Tween Bridge Solar Farm

9.6 Statement of Common Ground with Lincolnshire Wildlife Trust

Document Reference: 9.6

Statement of Common Ground

Figure 6.4: Landscape and Visual Mitigation Strategy

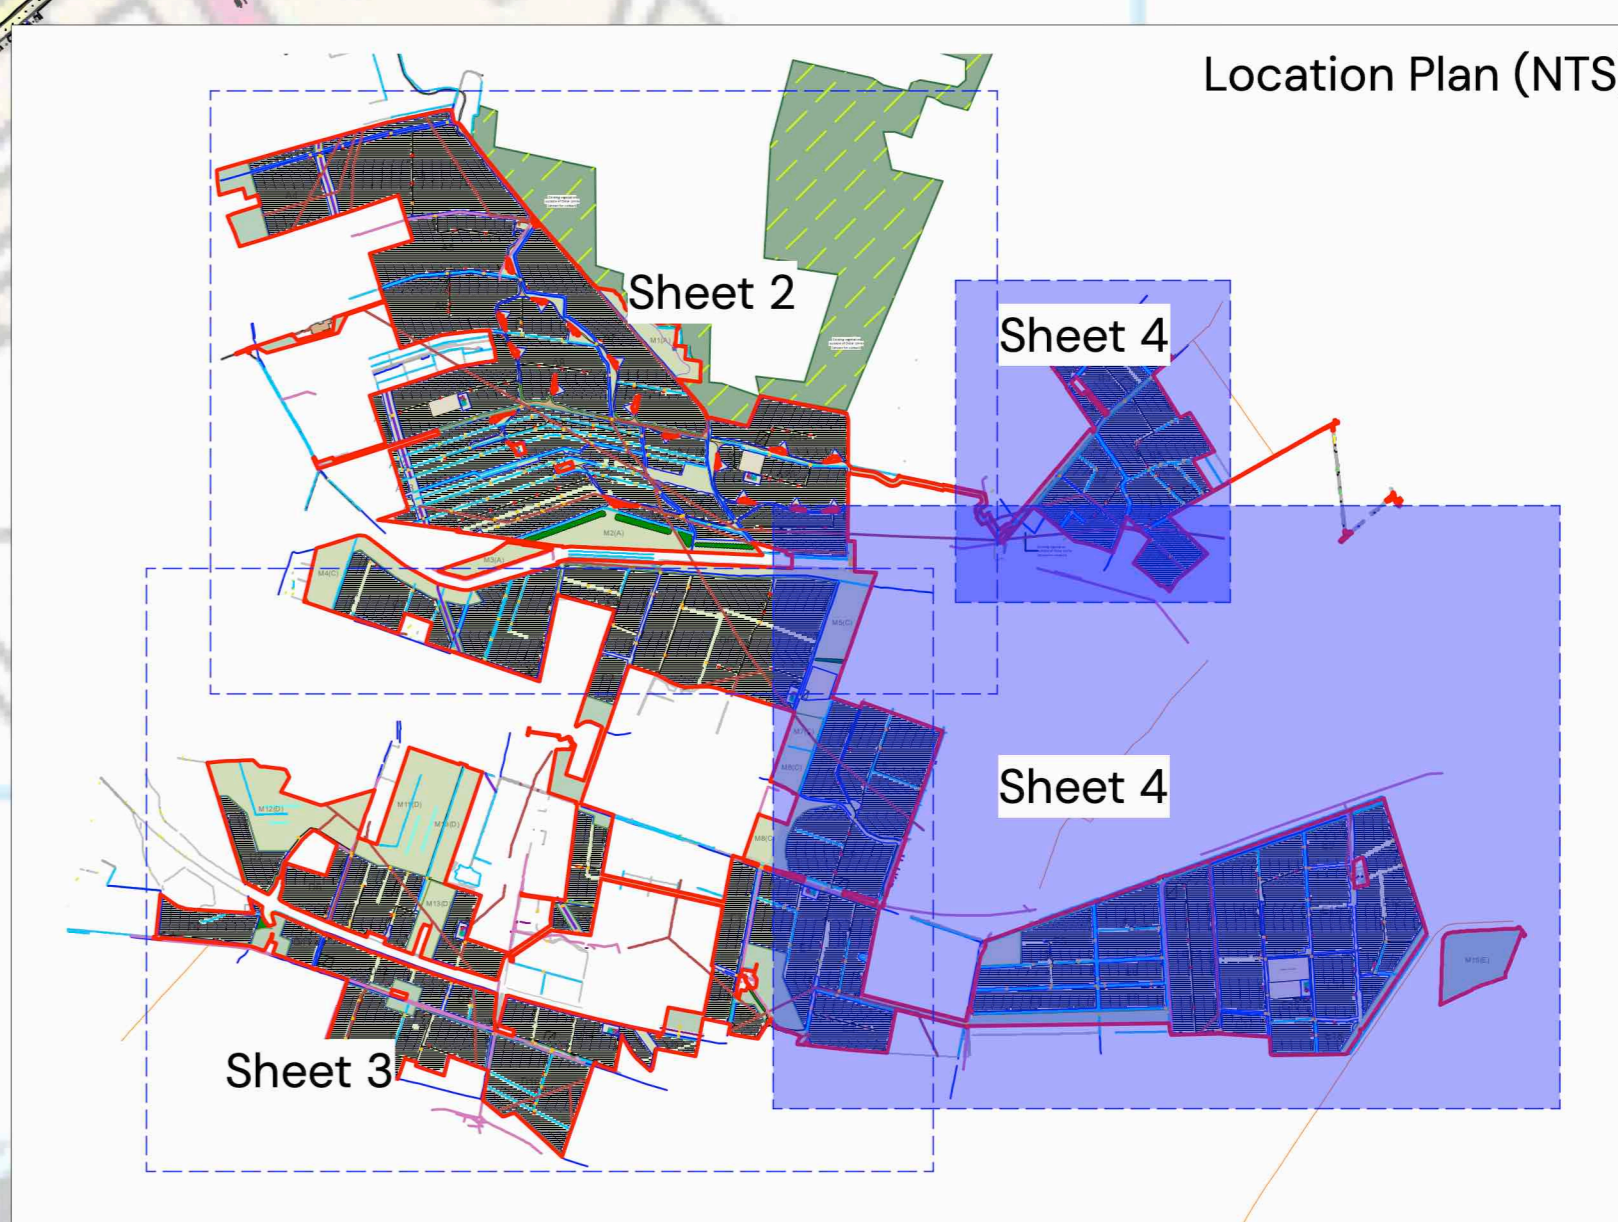
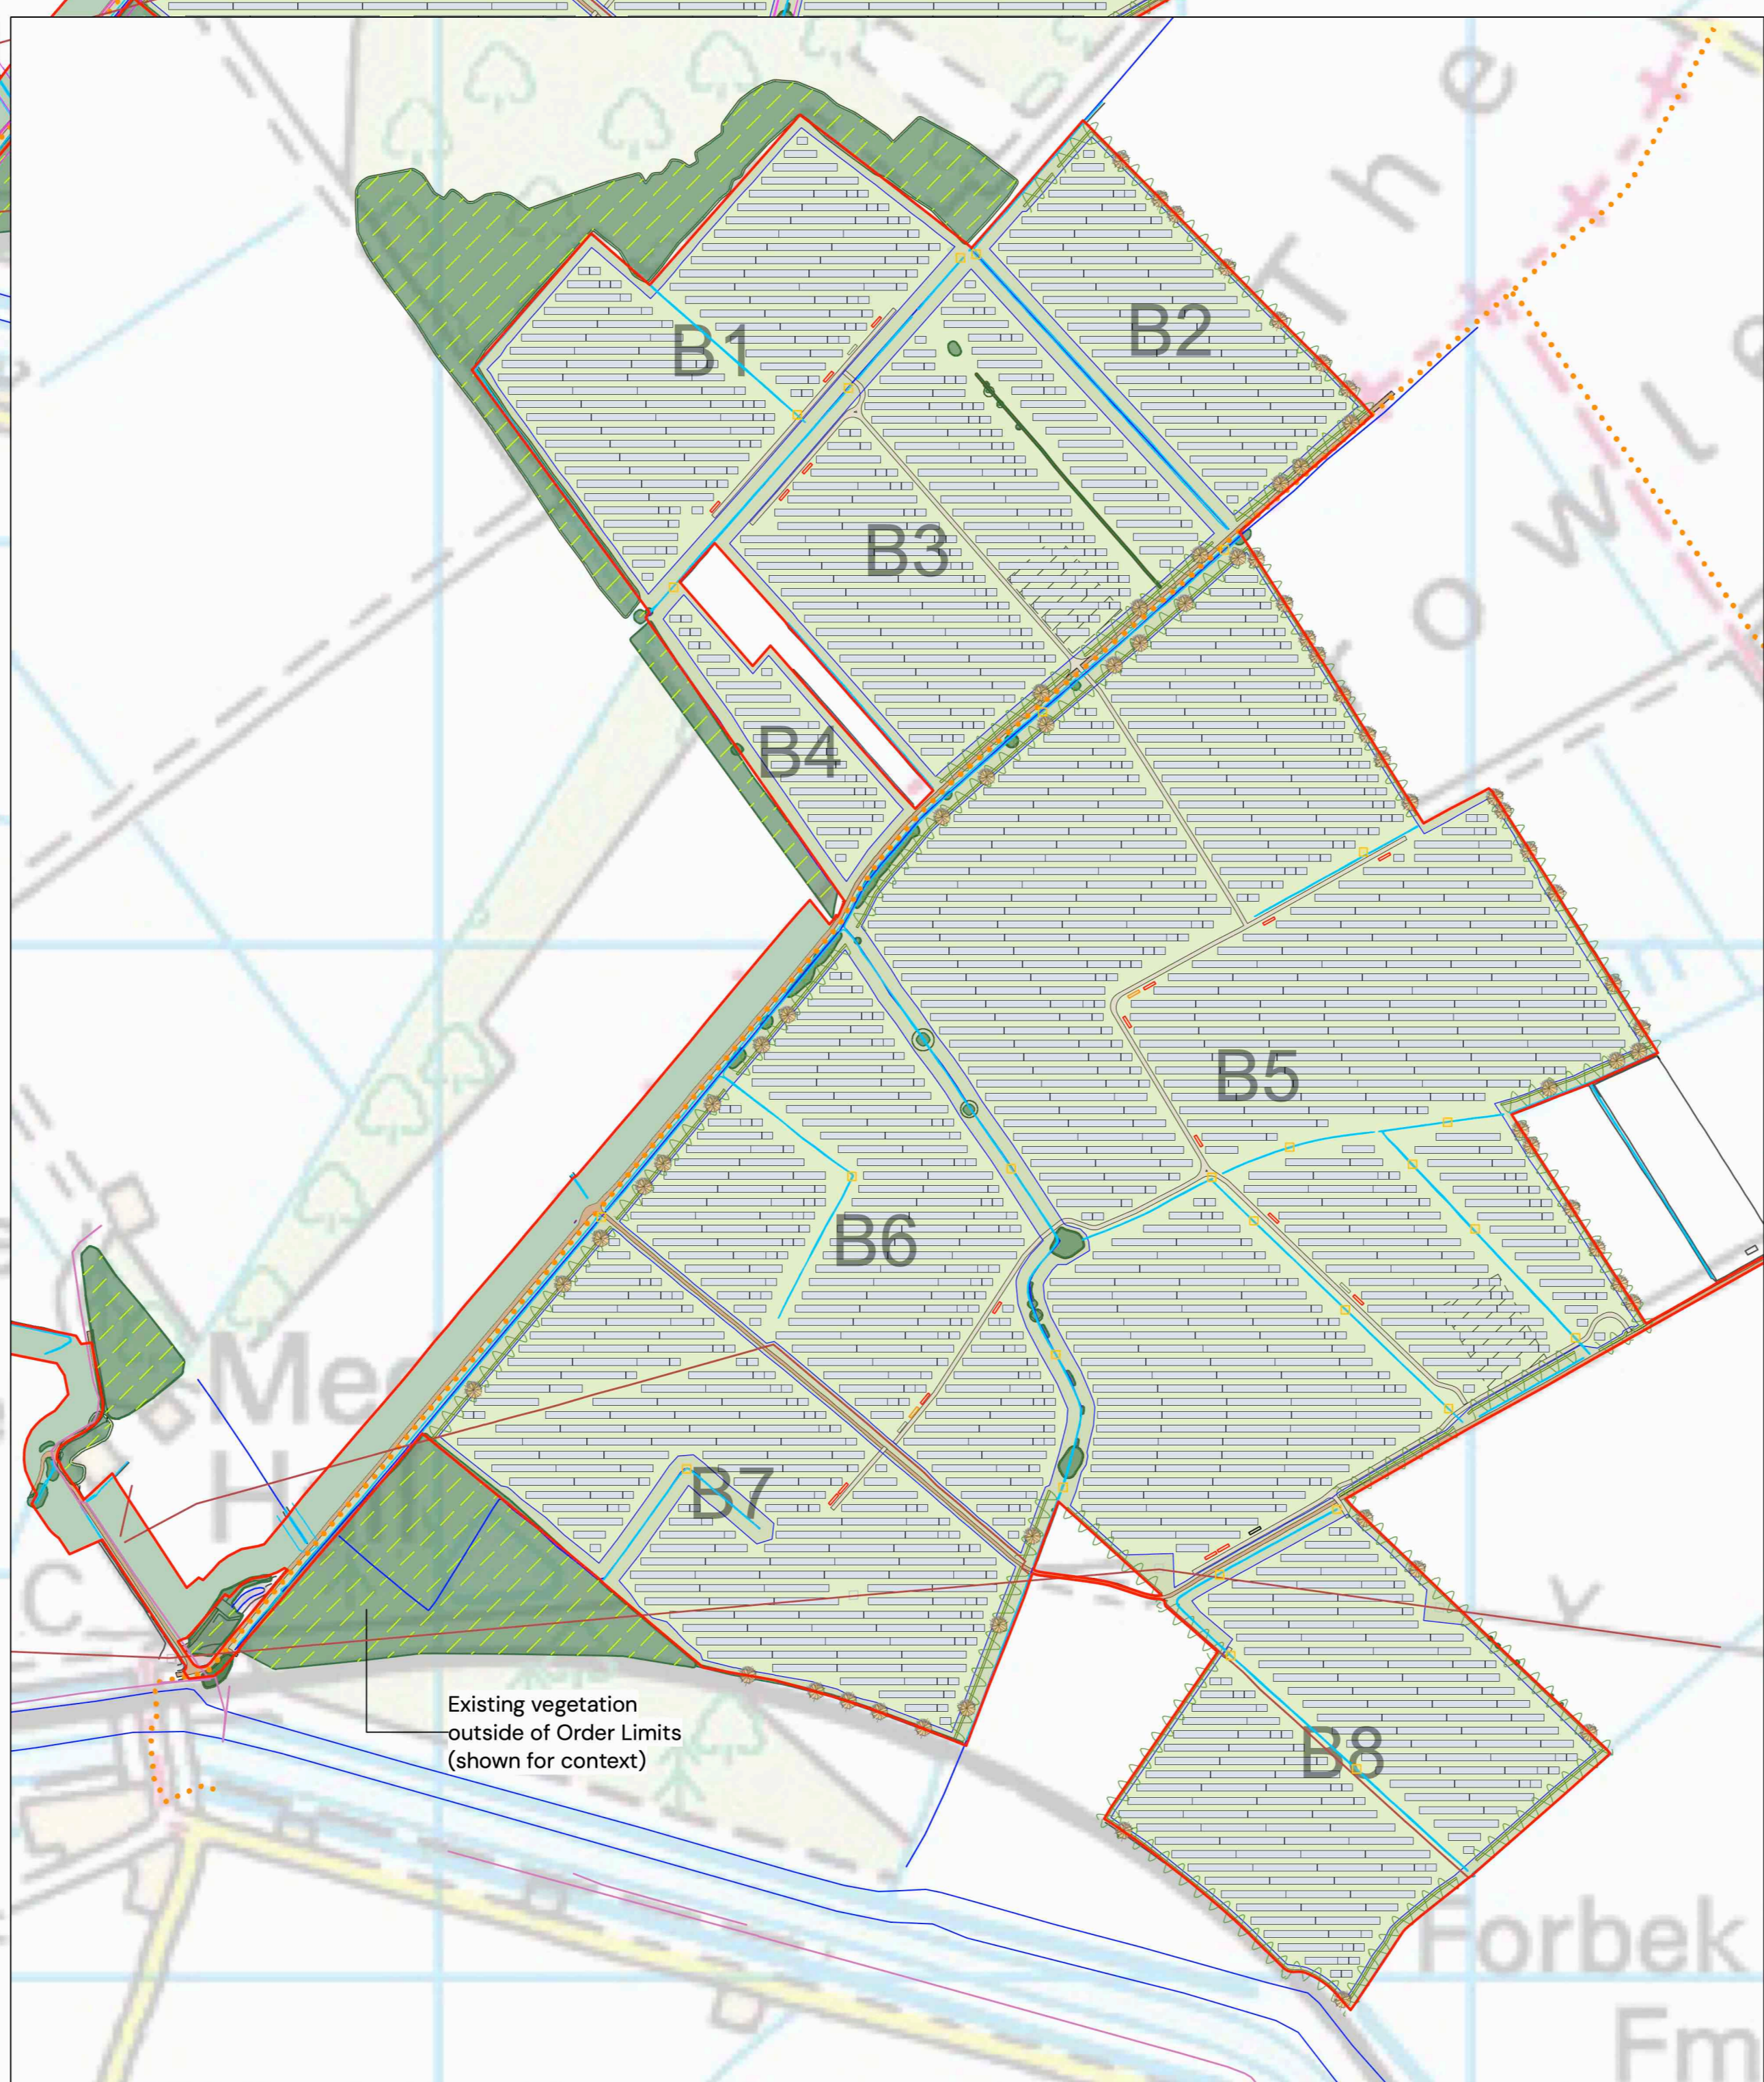
<p>Bird Impacts VI.</p> <p>In review of the breeding birds and non-breeding birds survey reports, we note the relative importance of Area B (Crowle) of the development, supporting a number of species which are present in significant numbers. For example, concentrations of species such as lapwing and golden plover. As noted by the applicant a number of species exceed the 1% threshold for Webs 5-year mean counts from the Humber Estuary SPA indicating usage as Functionally Linked Land.</p>	<p>VI. The Applicant acknowledges that there are a number of species that exceed the 1% threshold for Webs 5-year mean counts from the Humber Estuary SPA indicating usage as Functionally Linked Land, and consulted with Natural England regarding potential impacts and required mitigation.</p> <p>Given the mobility of SPA bird species, and the location of the Order Limits approximately 7.7 km from the Humber Estuary SPA, it is clear that SPA bird species travel large distances and will utilise suitable habitat where it is available and are not restricted to using habitat in only one location. This is supported by the breeding and non-breeding bird survey data recorded by the Applicant, which demonstrates that bird species move around the Order Limits and wider area and do not only remain in one part of the Order Limits, or rely on any specific area.</p> <p>With regards to lapwing the first years of surveys in 2022-23 recorded high numbers in Area B. However, in the second years of surveys in 2023-24 significantly lower numbers were recorded in Area B (17 in total), with higher numbers recorded elsewhere within the Order Limits, demonstrating that lapwing do not rely on any one area in the Order Limits.</p>	<p>Under Discussion</p>

The Applicant has designed the mitigation areas to reflect bird use where possible, whilst acknowledging that bird species move to areas of suitable habitat. As such, the mitigation design completed following consultation with Natural England has been designed to ensure the habitat requirement of bird species present, including those functionally linked to the SPA, are provided.	
		VII. We note and welcome the identification of need for a significant skylark mitigation strategy and provisions proposed with oLEMP to replace lost nesting opportunities with compensatory land allocation.	VII. The Applicant agrees that the Outline Landscape Ecological Management Plan [Document Reference 7.6 Revision 2] provides provisions to replace lost nesting opportunities and compensatory land allocation with regards to skylarks.	Agreed
		VIII. However, The Trust also notes with concern and reservation the distribution of the proposed bird mitigation parcels, and lack of proximity to Area B (Crowle). With reference to the bird survey results and species distribution it is apparent that a number of other species are aggregating in or near to the Crowle warplings. As recognised, warplings form a transitional habitat on the periphery of peatlands, and commonly create damp arable or wet grasslands supporting high densities of soil invertebrates. The proposed mitigation sites do not appear	VIII. As detailed above, the bird surveys undertaken by the Applicant demonstrate that bird species move around the Order Limits and wider area and do not rely or remain in one part of the Order Limits as detailed with ES Volume 2 ES Chapter 7 Ecology and Nature Conservation [AS-012] . Therefore, the Applicant has designed the mitigation areas to reflect bird use where possible, whilst acknowledging that bird species move to areas of suitable habitat. The Scheme's mitigation strategy can be seen in ES Figure 6.4 Landscape and Visual Mitigation Strategy [Document Reference 6.4.6.4 Revision 2] .	Under Discussion
